Application No: FP/137/21/HH  
Site Address: 10 The Grove Felpham PO22 7EX  
Description of works: Creation of new first floor and erection of single storey front porch extension following the demolition of existing garage and rear sun room

Thank you for your internet representation made on 2nd July 2021 which has been recorded as an objection with the comments as follows:

Proposed Elevations

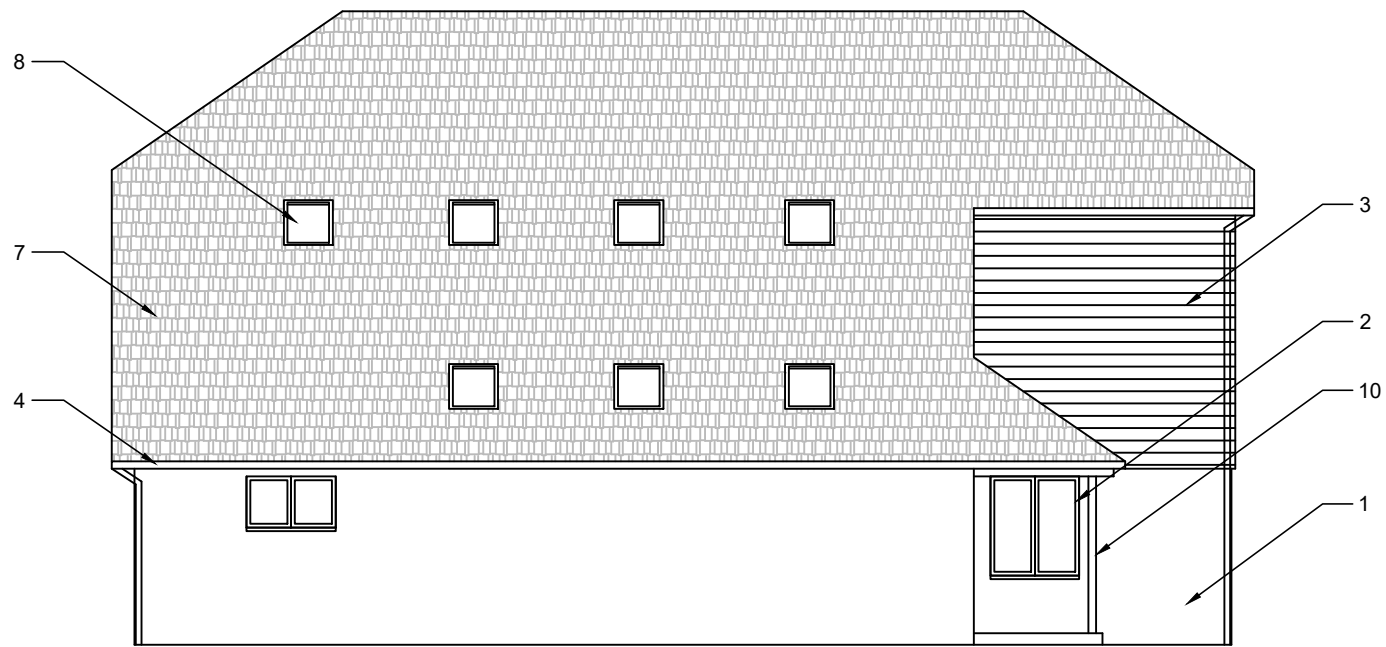
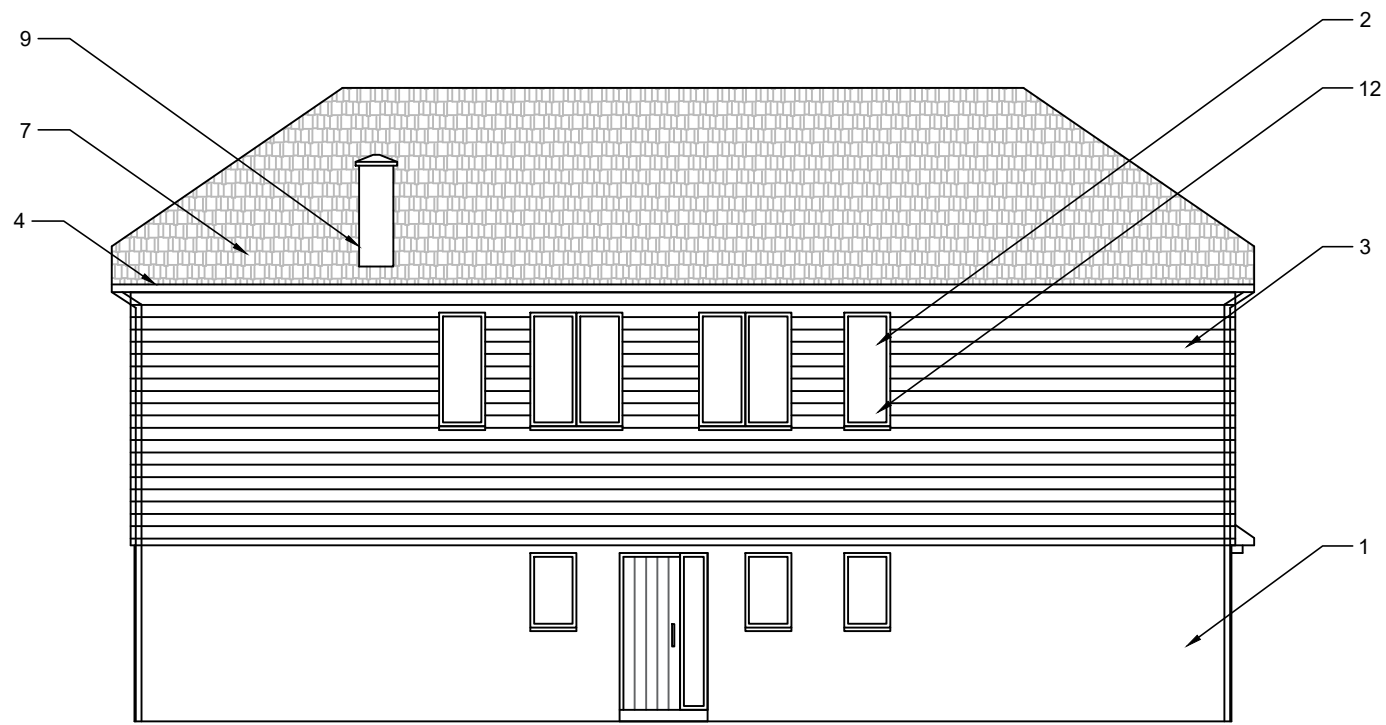
The proposed first floor extension will impact on my property next door by reducing light into my kitchen and lounge but also destroy the privacy I enjoy on my patio directly to the rear of my property. The plan shows velux windows to the north side of the proposed plan but if they are opening windows my privacy will be lost.
